Project Name:	Land at Bayards, Eastergate (Miller Homes)
Document Reference:	091.5016/SVR/3.2
Document Name:	SuDS Verification Report – Area 3
Prepared By:	Samuel Flesher
Checked By:	Meagan Weedon
Approved By:	Jon Soar

- 1.1 This Sustainable urban Drainage Strategy (SuDS) Verification Report – Area 3, has been prepared by Paul Basham Associates on behalf of Miller Homes to support the 'As-Built' verification report to Arun District Council in relation to Land at Bayards, Eastergate.

Section Pictures – 12/09/2023 – PS5299

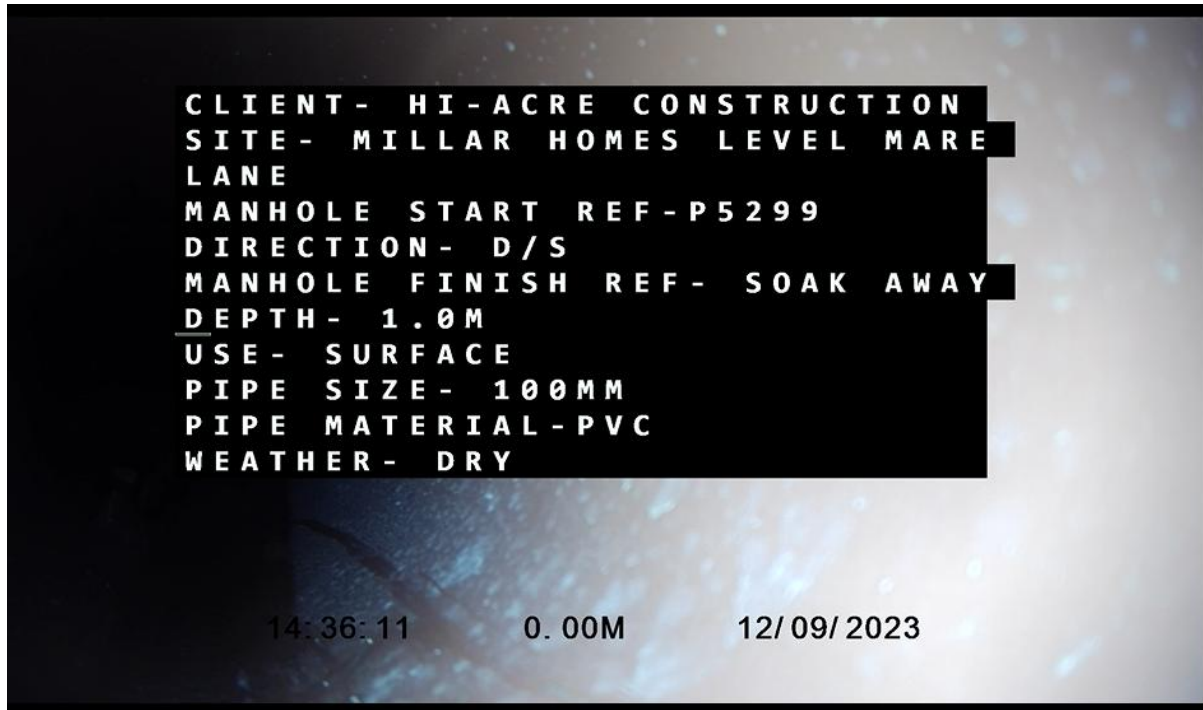
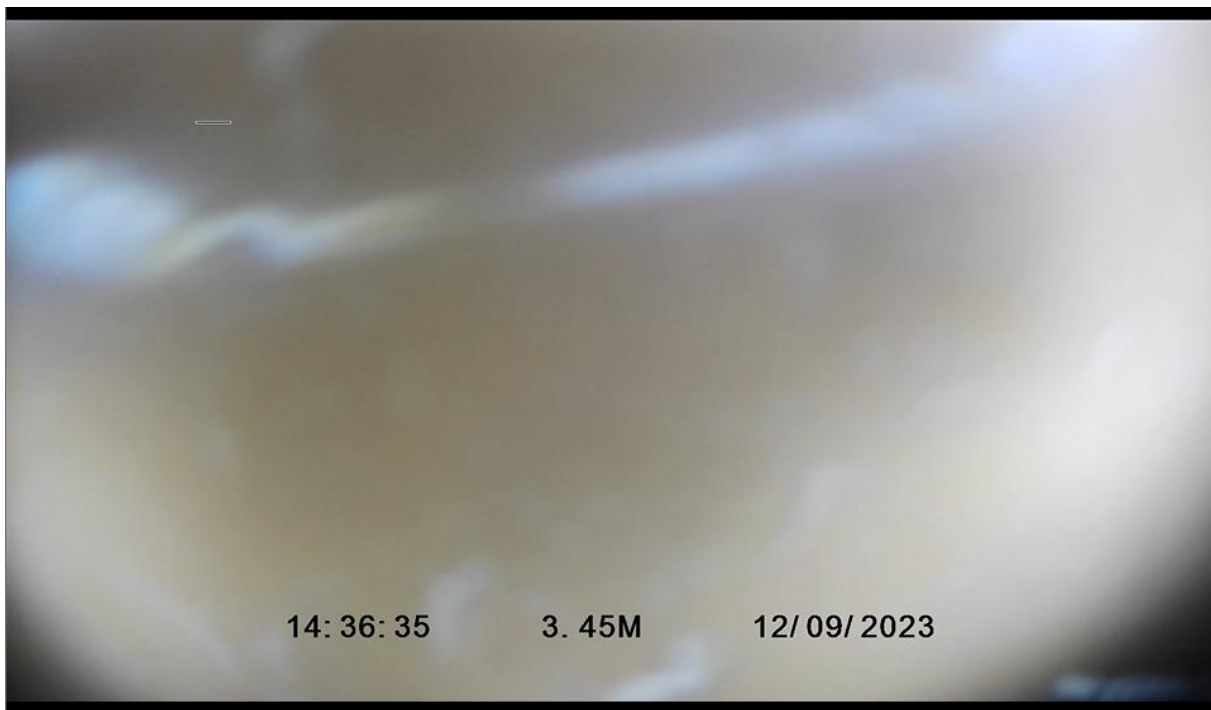
PS5285- PSCP298		Bend encountered, Chamber PS5285 does not appear to have been constructed.
PSCP298- PS5299		Large amounts of sediment build up, PS5299 looks to have been built as a catchpit manhole unclear if there are two catchpit manholes or PS5299 is the sole catchpit on the network.
PS5299-SA43- SA45		Pipe appears to change direction of slope, at ~1.5m into survey. The pipe appears to terminate above infiltration crates.
RWP (Plot 48) – PSCP330		RWP looks to have not been properly connected. No defects within pipe sediment build up could suggest pipe has been laid at a shallow gradient.

Section Pictures – 12/09/2023 – PSCP228

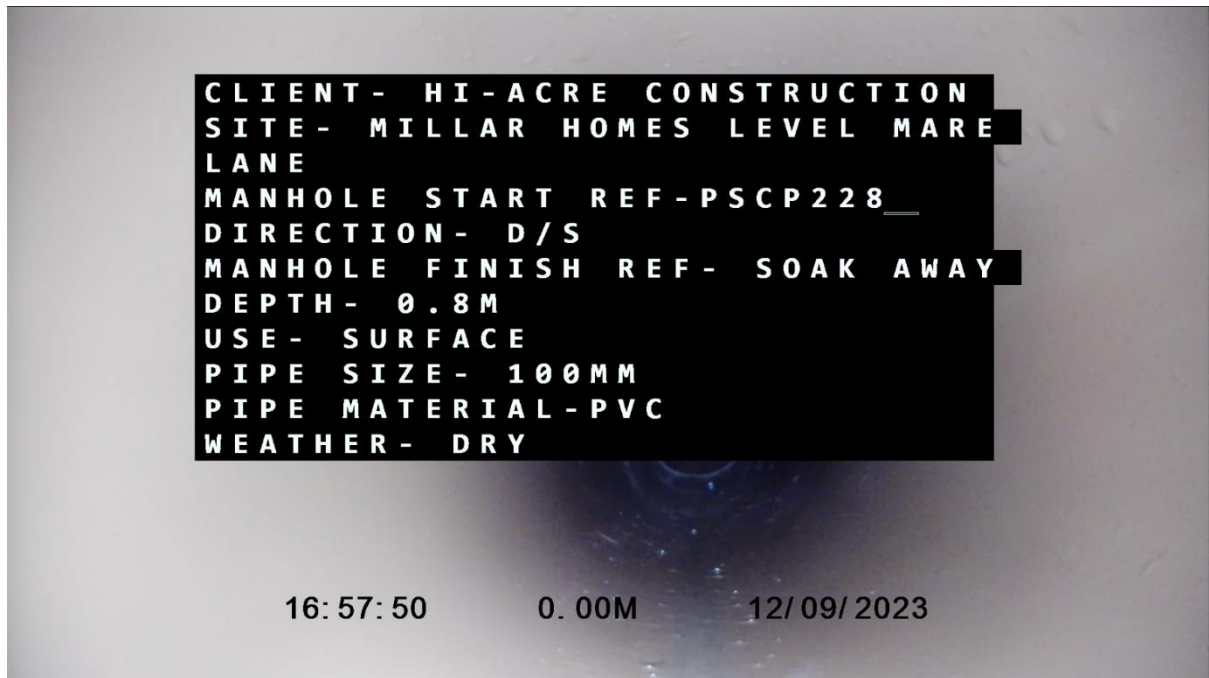
PS5270-PS227		Small amount of water present in PS227
PS227-PSCP228	Survey not recieved	
PSCP228-SA51		Pipe displacements due to spiral cuts in pipe, pipe has changed direction due to settlement.
PS5283-PSCP231		No defects
PSCP231-SA52		Pipe displacements due to spiral cuts in pipe.

- 7.5 The remedial works required within Area 3 is as listed below:
- The Contractor shall obtain written approval from crate supplier that the constructed soakaways comply with their specification. Notwithstanding this requirement, it is recommended that all damaged or deformed pipes be removed and replaced.

Section Pictures – 12/09/2023 – PSCP330

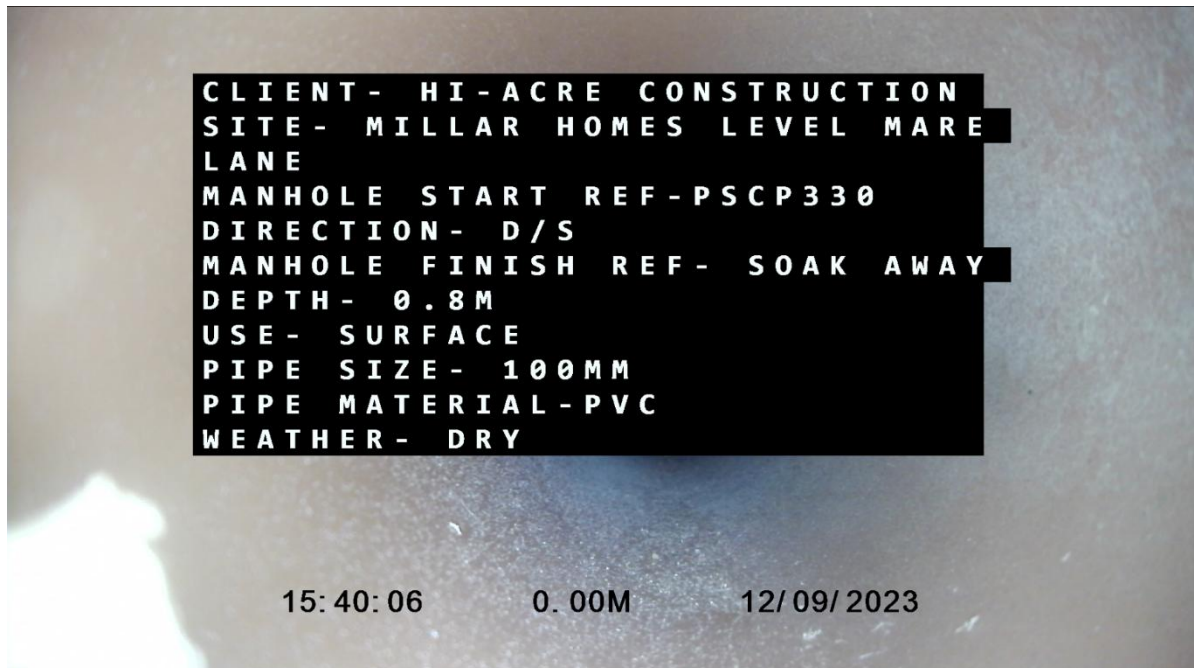
PSCP330-SA48		Pipe appears to change direction twice and spiral slits have been cut into pipe. From the images in section 4.4 there is two pipes coming into the crate system, the other pipe will need to be surveyed and a catchpit manhole must be installed upstream of this pipe.
PS334-PSCP335		Standing water and large amounts of sediment build up in PS334. Water does not appear to be flowing downstream suggesting that the pipe is back falling
PSCP335-SA49		Pipe displacements, deformed pipe due to spiral section cut through the pipe. Pipe appears to have moved away from joint in image.

Section Pictures – 14/09/2023 – S5

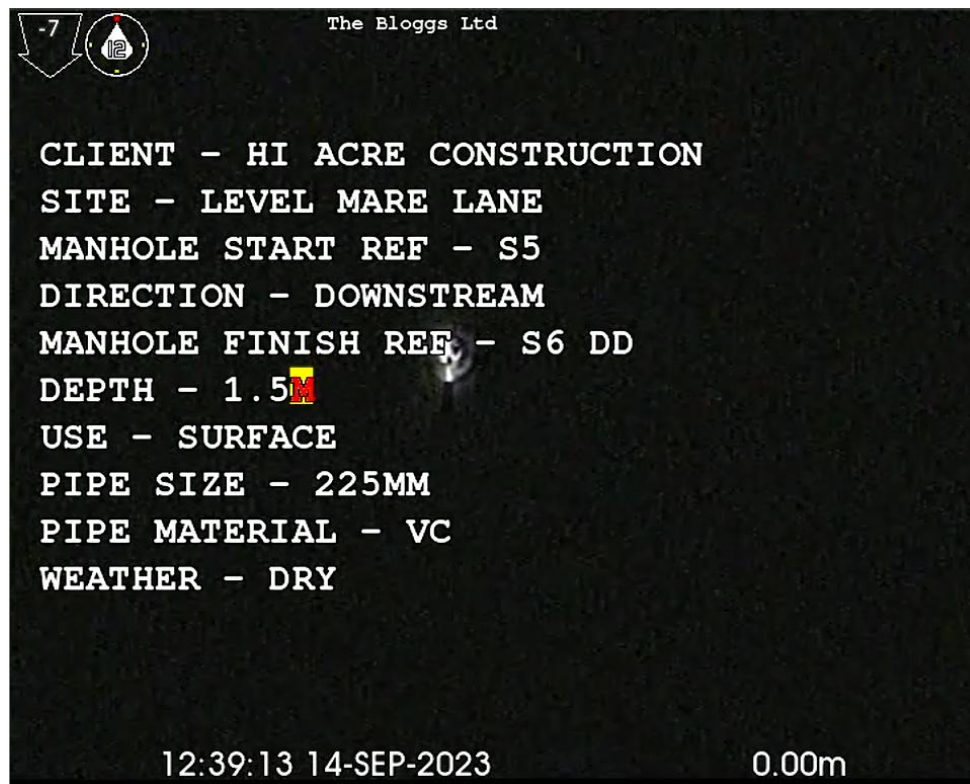
Ref	Defect Images	Comments
S26-S5		S26 Depth 1.35m As Built Depth 1.31m Video terminates at 19.60m Design length 22.48m No Defects present
S5-S6		Depth 1.5m As Built depth 1.38m Longitudinal cracking present at 7.95m Video terminates at 12.48m Design length 16.809m Downstream defender does not appear to have been installed in S6
S6-SA Road 2	No footage provided	
RE5721-PS235		No depth given in video, Video starts at 9.89m video ends at 3.17m Design length: 11.011 No junctions for RWP were visible in survey No defects
PS235-PSCP236		No defects
PSCP236-SA38-39	No footage provided	
PS243/PS5297-PSCP240		Standing water at start of survey- suggests the pipe is back falling
RWP-PSCP240		Video starts at 3.17m No Defects

- 7.1 Provide images of SA Road 2 during construction and CCTV S6 to Soakaway.
- 7.2 Chamber S6 the Downstream Defender Vortex Plus has yet to be installed, this will need to be installed.

Section Pictures – 16/05/2024 – PSCP249

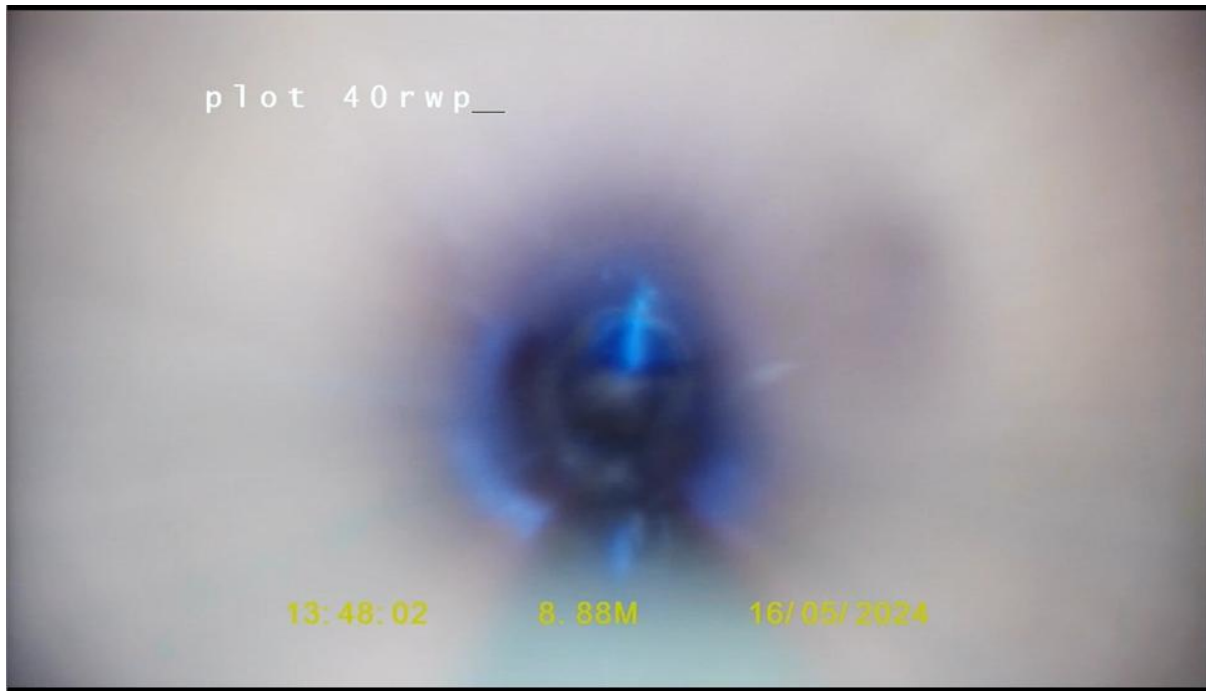
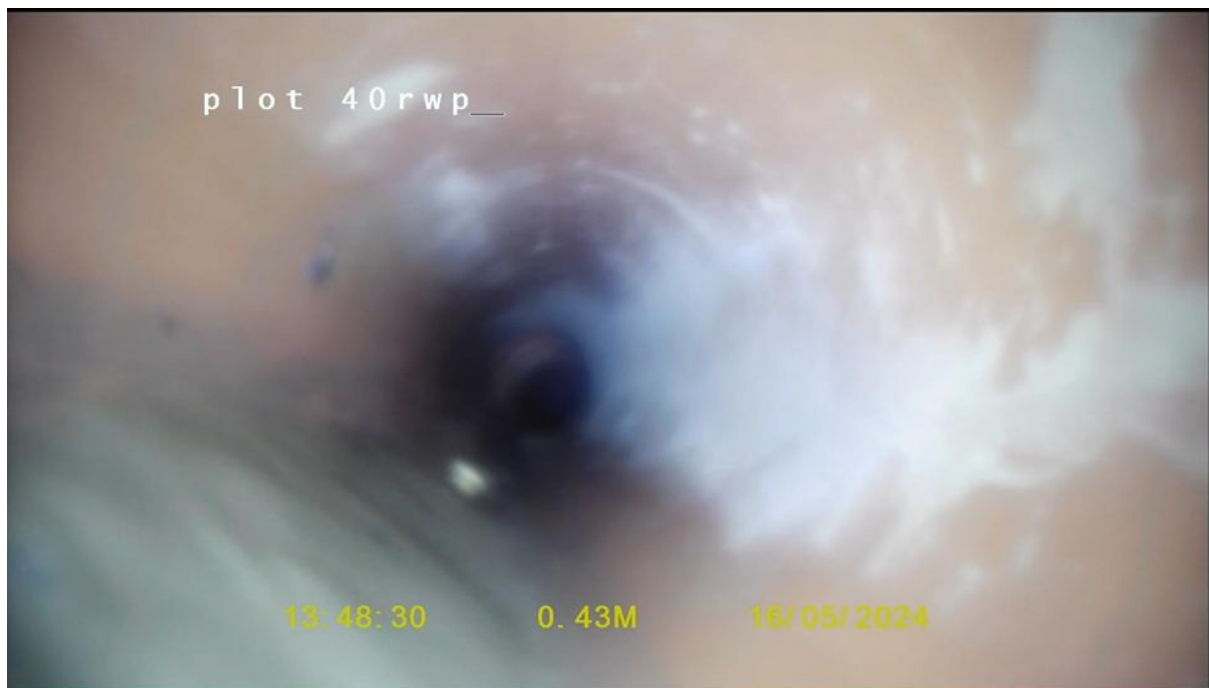
PSCP240-SA38/39		Semi spiral cuts present on the video, causing the pipe to bend. Pipe also not cleaned after being cut and signs of debris from cuts present. CCTV survey shows the pipe is back falling.
PS243-PSCP249		Video labelled as Plot 40 RWP, suggesting that the RWP is connected directly into PSCP249 and that PS243 chamber was not constructed. Standing water present in pipe downstream, unclear if this was due to poor drainage or recent weather, no recent weather was provided.
RWP (Plot 41) – PSCP249		View blocked by obstruction but appears to be no defects.
PS248-PSCP249		Survey appears to terminate at a bend suggesting that PS248 chamber was not installed.
PSCP249-SA40-42		No defects
PS5272-PS253		Unclear if full length of sewer was surveyed as upstream manhole could not be seen No defects
PS253-PSCP254		No defects
PSCP254-PS3301		No Defects
PS3301-SA43-45		damage to infiltration crates has been caused due to inadequate connection. No defects within pipe
